Application by Medworth CHP Limited for an Order Granting Development Consent for the Medworth Energy from Waste Combined Heat and Power Facility

We are writing on behalf of Cambridgeshire County Council and Fenland District Council (the Cambridgeshire Authorities) regarding the Medworth Energy from Waste Combined Heat and Power Facility Development Consent Order (DCO) Examination.

Comments on the Applicant's D2 Submissions

- Notes:
1. Proposed visibility based on New Bridge Lane being subject to a revised 30mph speed limit.
  2. New street lighting has been provided on an indicative basis (at 30m intervals and at conflict areas) and will require detailed design and assessment.

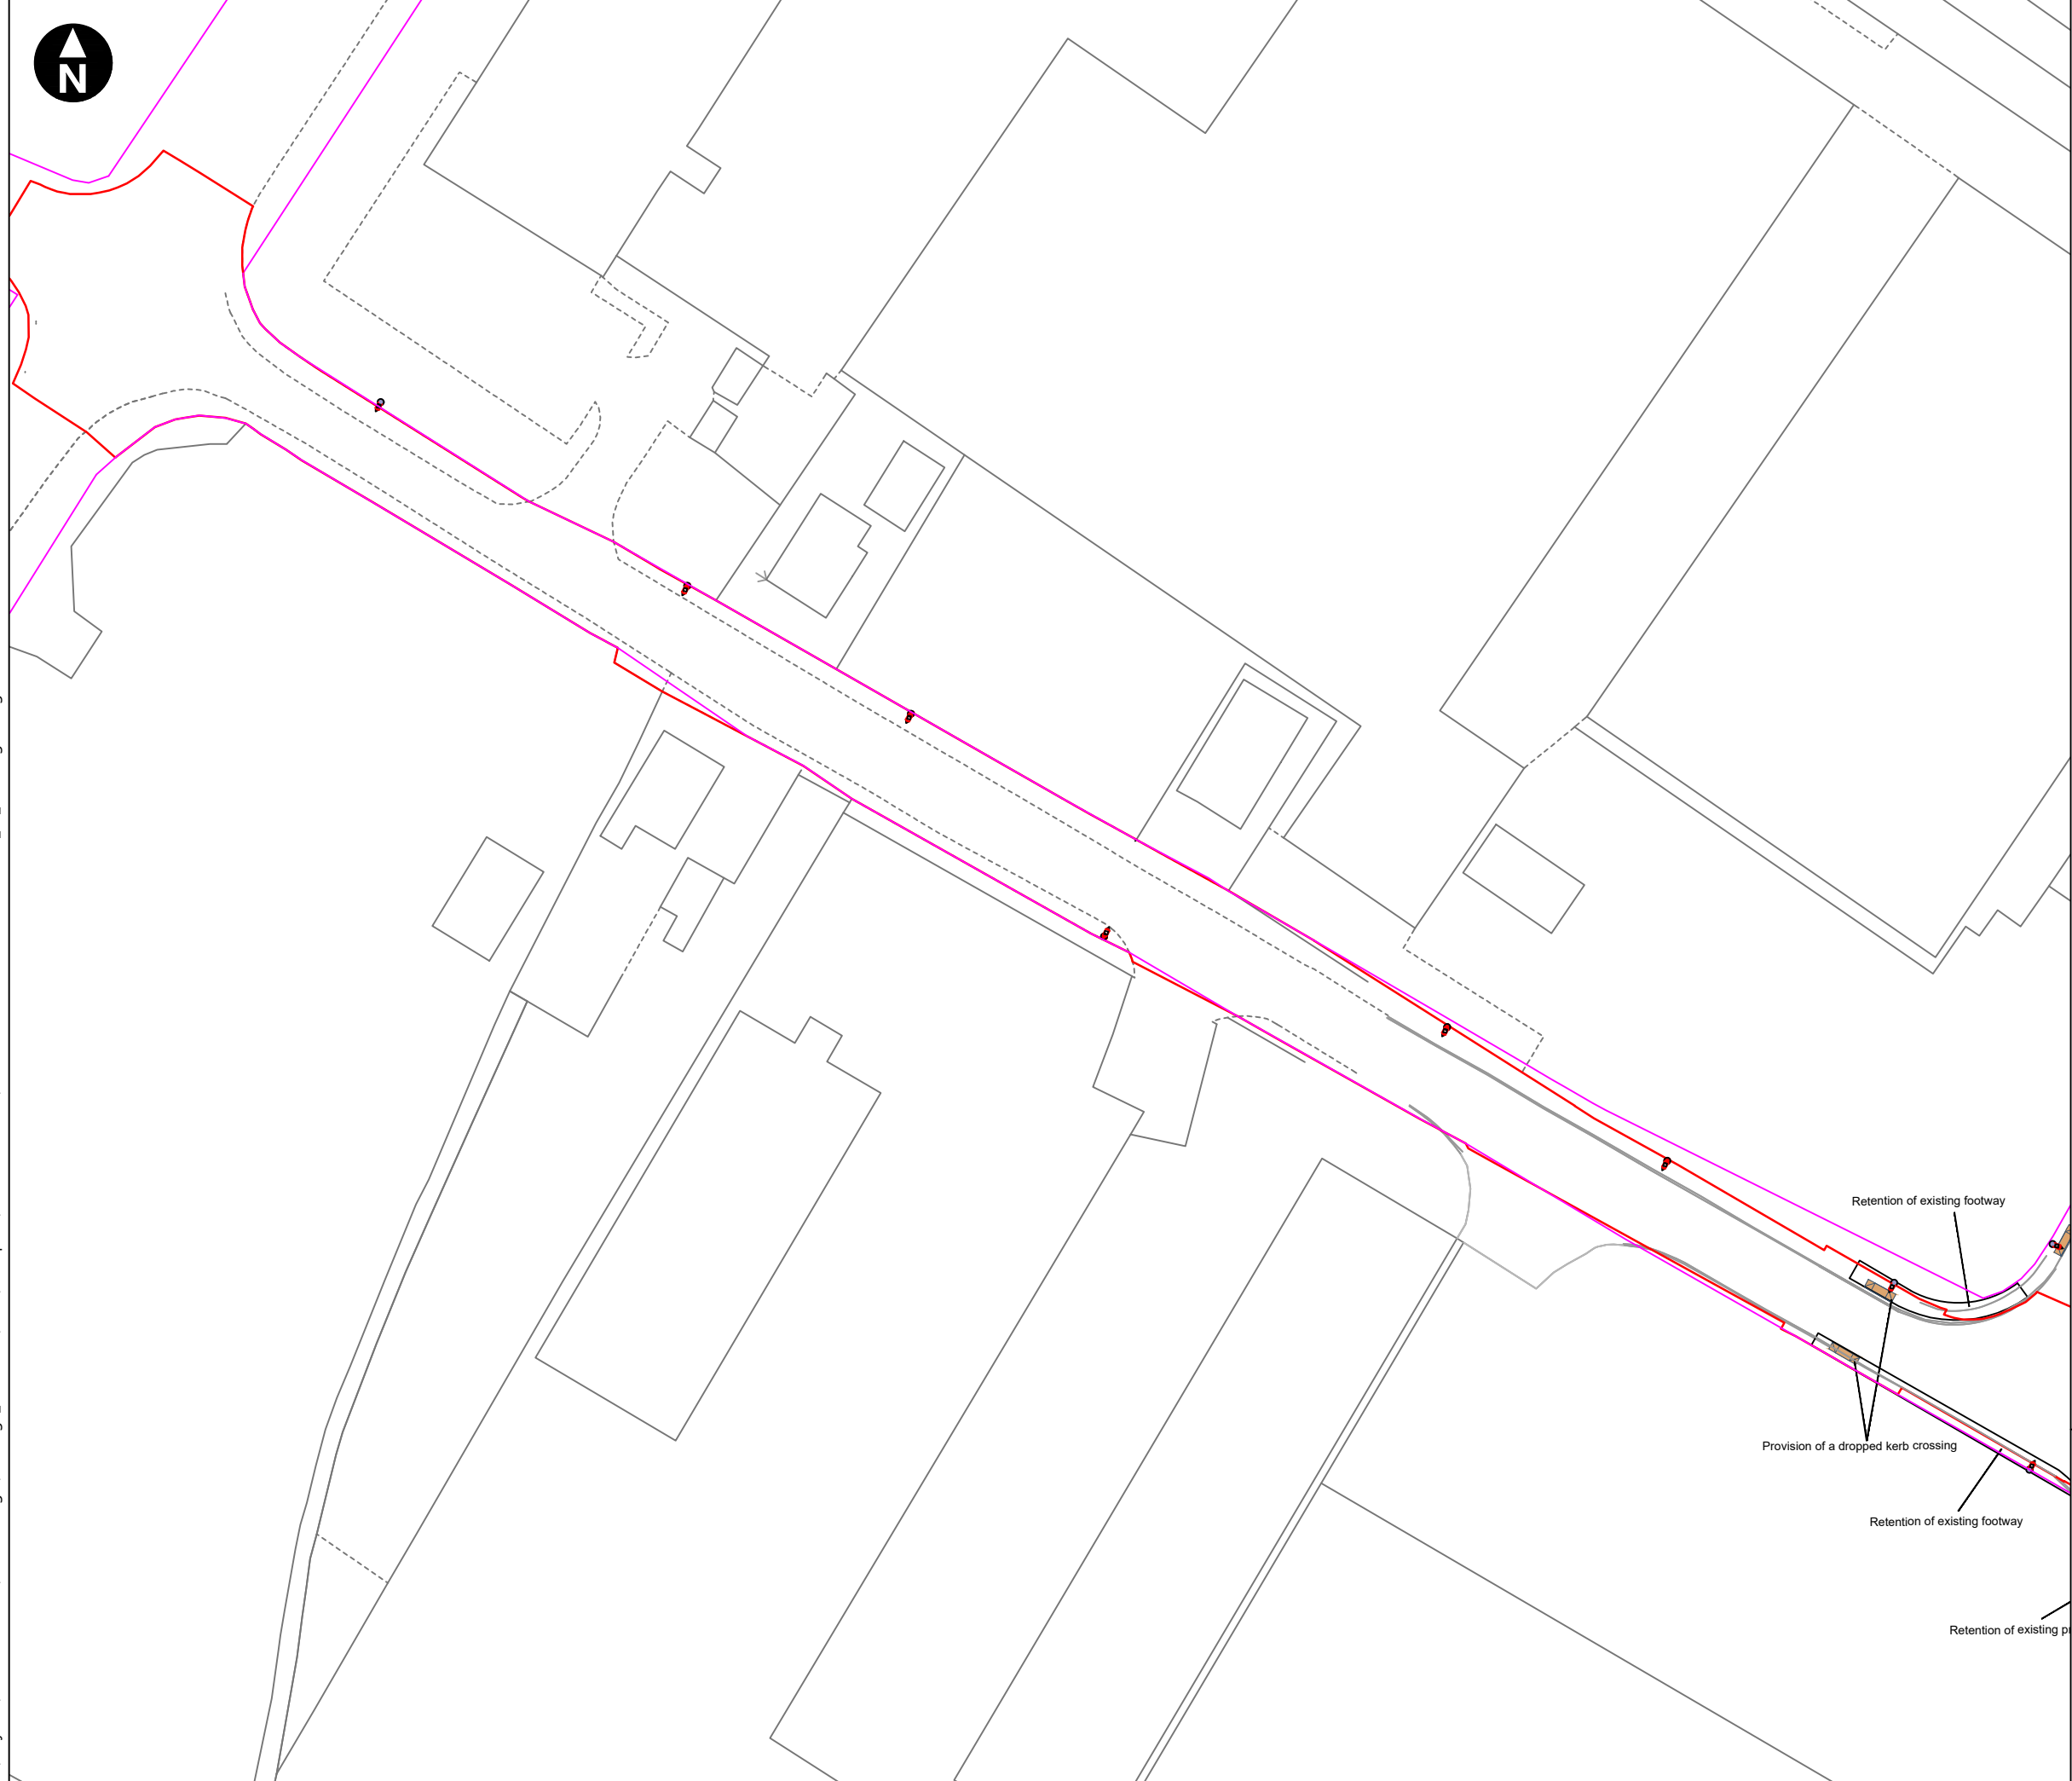
<p>Public rights of way: Construction and Operational Phase Impacts on NMUs and local communities</p>	<p>2.16 and 2.17</p>	<p>CCC has engaged directly with the applicant regarding the impact of its proposed works on the PROWs, Wisbech Byway 21 and Elm Byway 6. These two PROW adjoin the A47 at opposite sides of the carriageway, and therefore in order to continue from one PROW onto the other it is essential to cross the A47. It is noted that the draft DCO boundary does not include any part of these two PROW, however, the proposed linear construction works in the A47 corridor would indirectly affect these two PROW by creating a temporary severance in the ability to cross from one to the other.</p> <p>The works on the A47 are therefore inseparable from the two PROW, and yet no indication of this is present in the draft DCO. CCC welcomes the ongoing engagement with the Applicant regarding this matter and is seeking to agree amendments to the CTMP and OTMP to ensure the impact on these PROW is suitably mitigated. Further work is required in order for the Council to be satisfied that adequate protective provisions are in place.</p> <p>With respect to NMU access along New Bridge Lane, the Council appreciates that this is an unclassified road rather than a PROW, but the context is that Wisbech and the surrounding fenland area have very poor provision of PROW due to their historic nature, and so local roads can provide important connectivity for NMUs where no other facilities exist. This access therefore needs to be seen within the broader policy framework envisaged by NPPF para 100, the Defra 25 year Environment Plan, the ROWIP and the Joint Health & Wellbeing Integrated Care Strategy, working together. As noted in the Council's response to the Applicant's response to ExAQ1 LV 1.3-1.6, the Council welcomes the proposed measures to improve the environment along New Bridge Lane during the operational phase as set out at 2.17.4, p48 of the Applicant's response, but considers that such measures will not be able to completely mitigate the adverse impact of the development on NMUs and the local community.</p> <p>The Outline Operational Traffic Management Plan (OTMP) [REP1-025] does not address the impact that operational traffic will have on NMUs using New Bridge Lane, post-construction. In particular, the section of New Bridge Lane that is to the east of the former level crossing, would, under the Applicant's design (shown in the Figures section of the Outline CTMP [REP1-011]), result in a narrow rural lane that is quietly trafficked becoming a ~7m wide carriageway with a 2m footway alongside it. All green verges in this section appear to be</p>

<p>removed. The physical nature of this part of the road will be transformed and it will be opened to use by HGVs. NMUs will be corralled from a quiet rural road with spacious verges onto a 2m footway running adjacent to an HGV route, with no apparent off-carriageway provision for cycles. Consideration of equestrian users is absent.</p> <p>A signage strategy for NMU traffic is also absent. This is of particular concern in relation to the former level crossing, where it is important that NMUs are not given any impression that the works have diminished their ability to pass and repass. CCC requests that it is consulted on the wording of any signage in this location to ensure that NMUs are not discouraged from using the route. Further to this, rather than relying upon private agreements with Network Rail, it would be preferable if a public permissive agreement for access across the level crossing were reached. This would provide reassurance to the Council and to public users that the ability to use the route has not been diminished. The Council requires involvement in the making of such an agreement. The Council refers to its additional comments regarding the access over the level crossing at 2.4.6 above.</p> <p>Further, the Council notes that there will also be wider visual landscape impacts affecting recreational users of a number of existing PROW and local roads broadly south and west of the development. Therefore, the Council seeks additional mitigation, as set out in its response to the Applicant's response to the ExAQ1 LV 1.3-1.6. There is scope for such mitigation to help meet the problem of insufficient BNG provision through a solution that involves the provision of appropriate habitat which includes public access provision within the vicinity of the development and local community affected. The Outline Landscape and Ecology Management Plan [APP-098] should be amended to reflect the adverse impact on recreational use of PROWs and local communities within the wider landscape, and should propose appropriate mitigation. The Council would welcome engagement with the Applicant to discuss this further.</p>
